WEST SUSSEX COUNTY COUNCIL PLANNING SERVICES CONSULTATION

SUBJECT: AB/60/17/PL - 1 No. dwelling with carport & associated off street parking (resubmission following AB/130/16/PL).

Land rear of, 74 & 76, Canada Road, Arundel, BN18 9HY

Block Plan 1:500

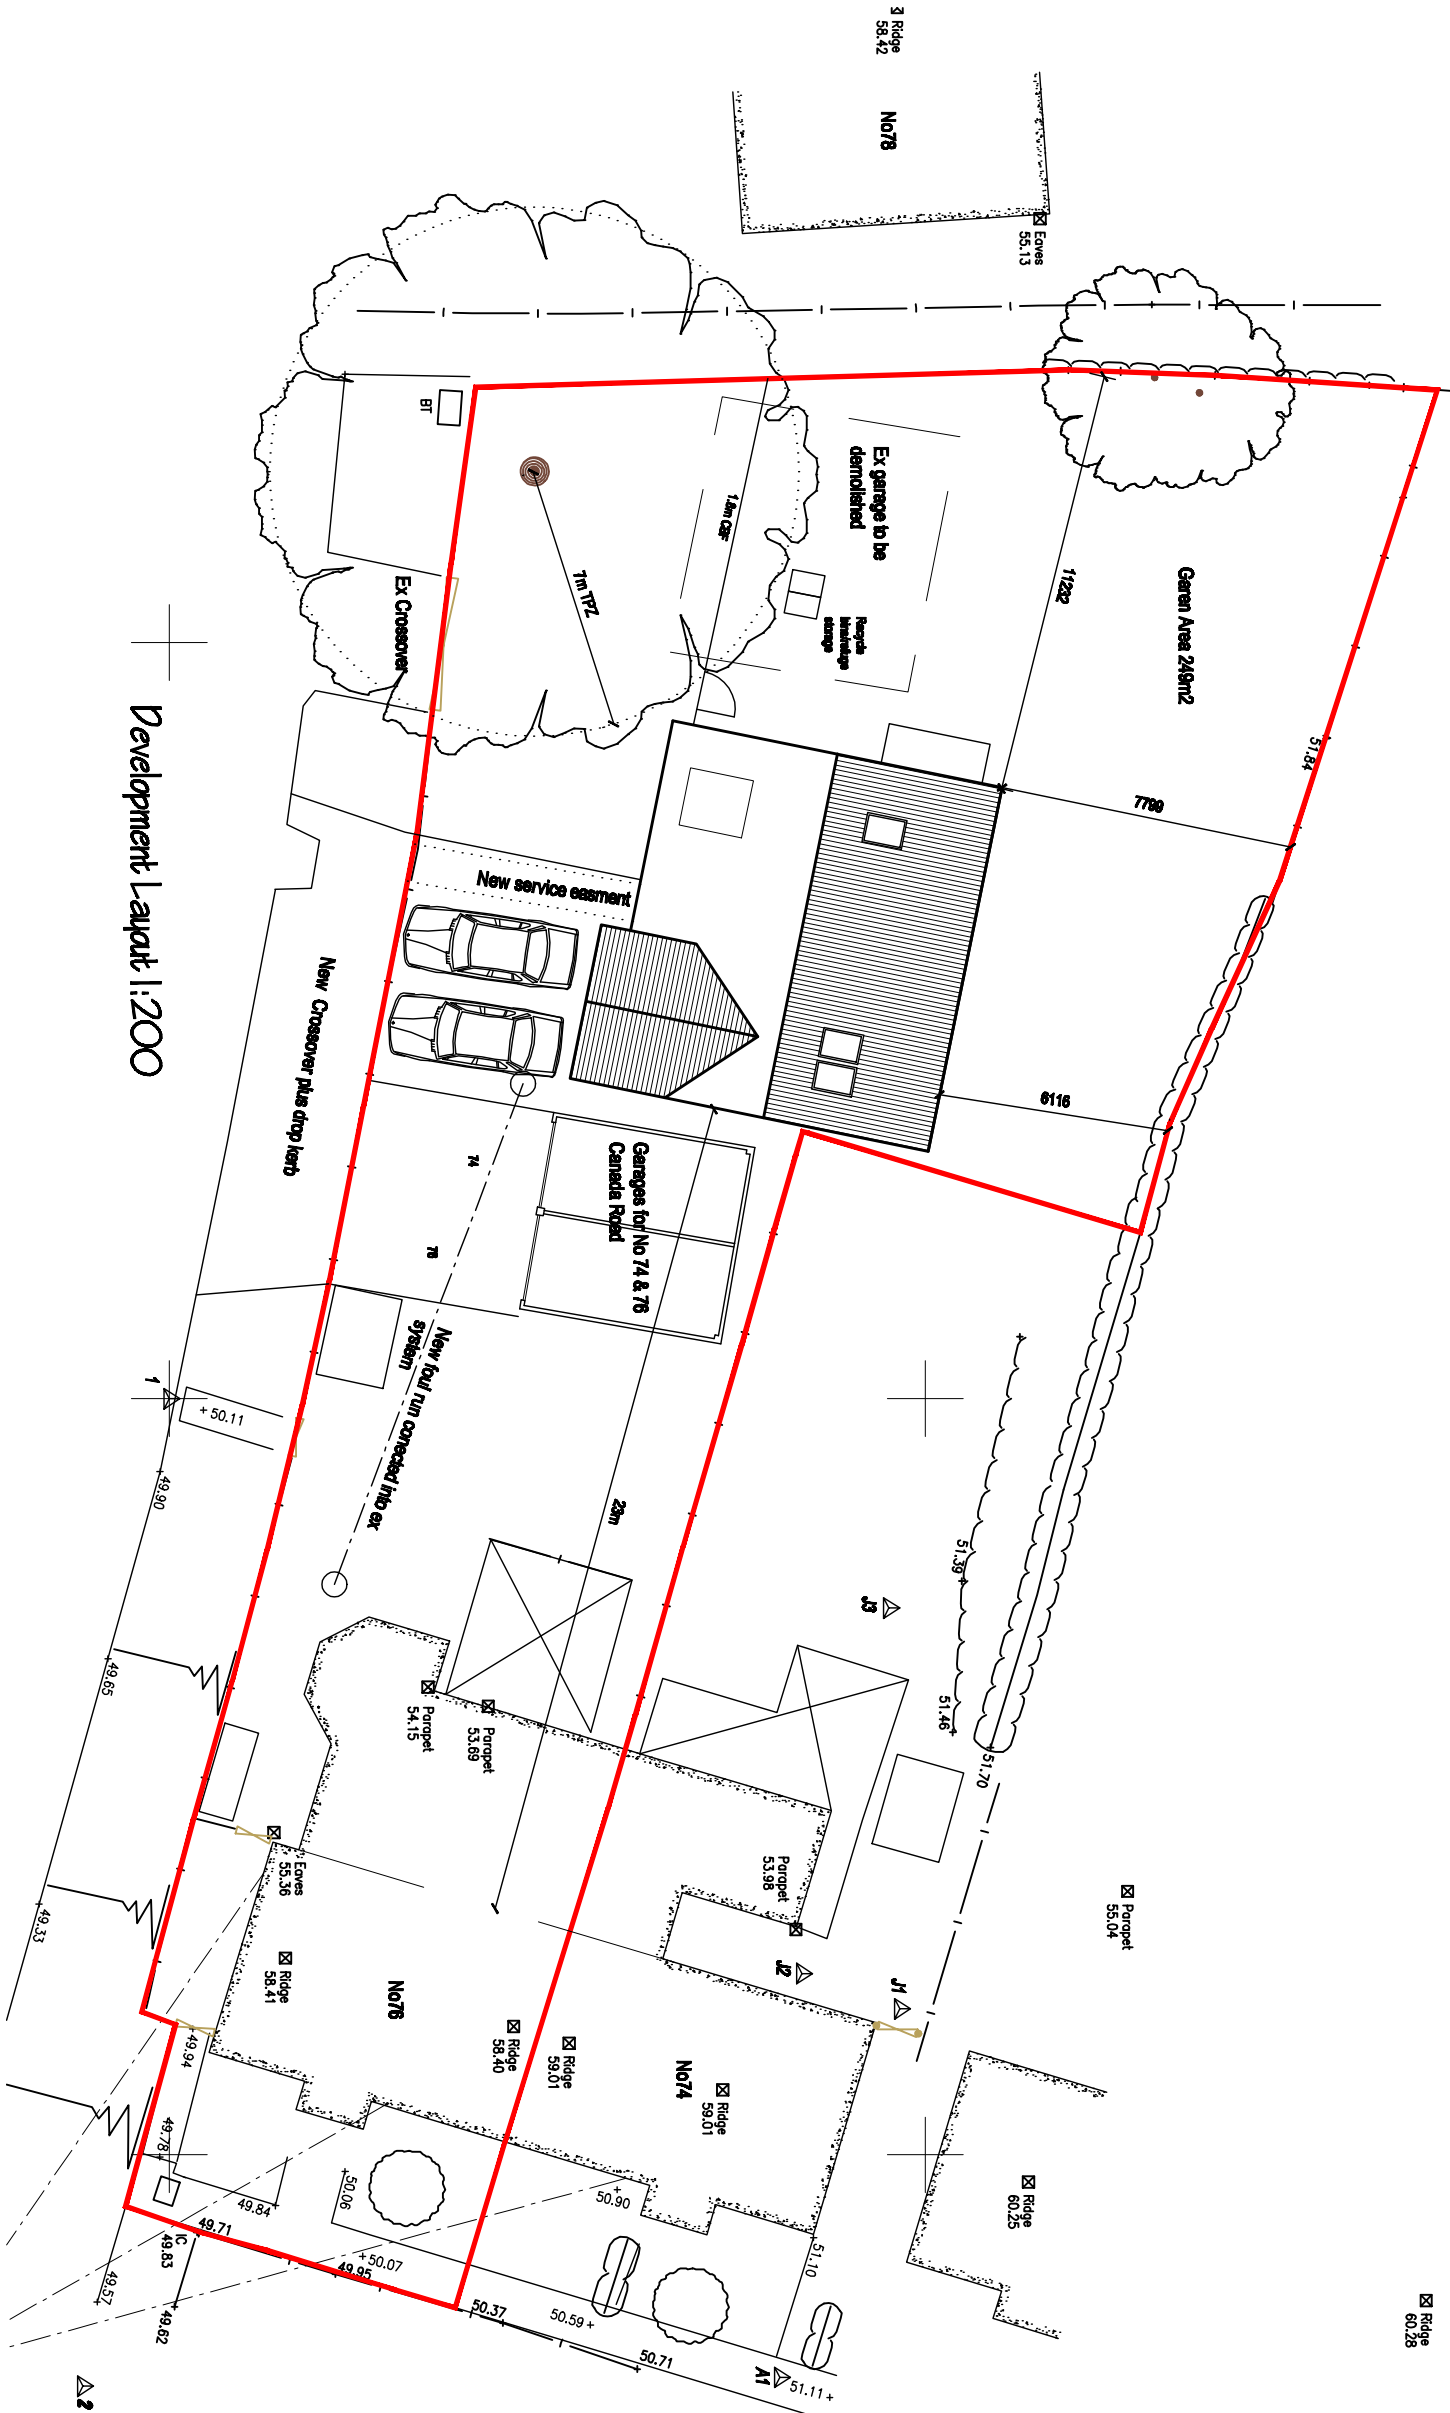
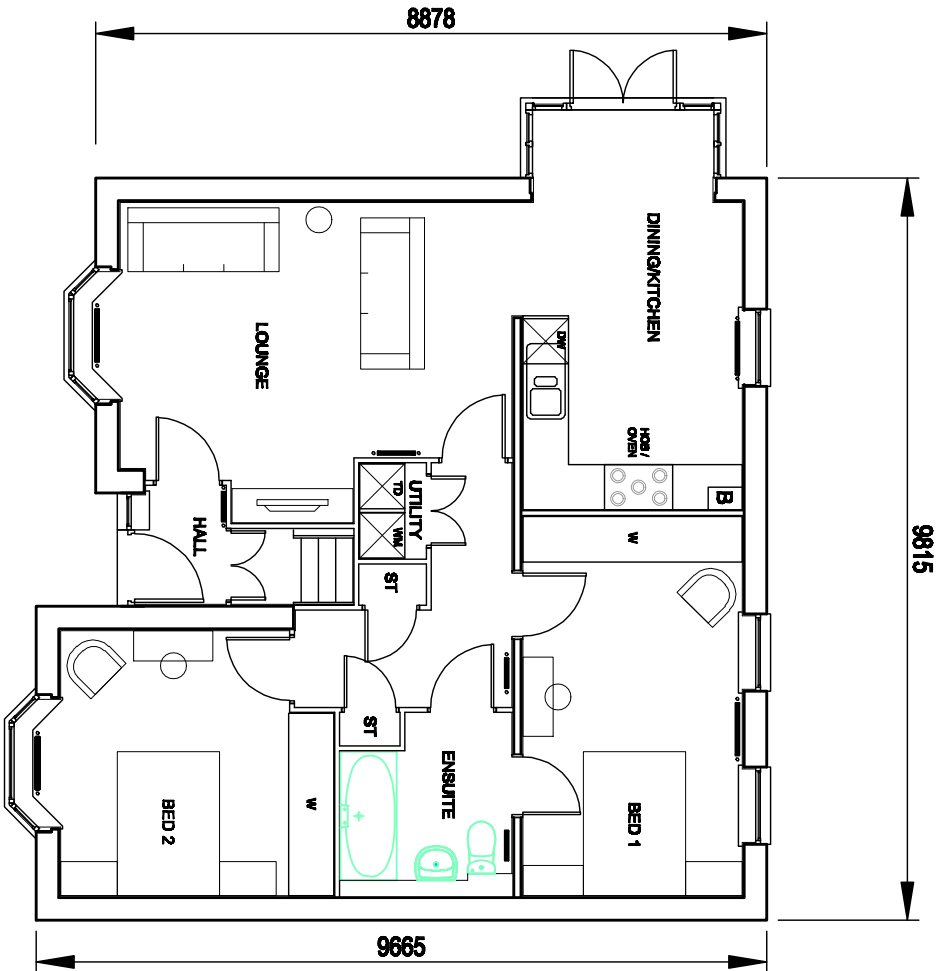
A study of the block plan demonstrates that off street parking to serve the new dwelling will be provided for 2 vehicles. This is in accordance with the WSCC Parking Demand Calculator. The LHA would prefer that a turn on site is provided to enable vehicles to exit onto the highway in a forward gear, however, there does not appear to be sufficient space to achieve this. The drive is to be constructed using tarmac; this is in accordance with WSCC guidance which advises against the use of gravel/shingle to prevent overspill onto the public highway.

An inspection of the plans establishes that the dimensions for the new double car port to serve nos. 74 & 76 meet with WSCC guidance.
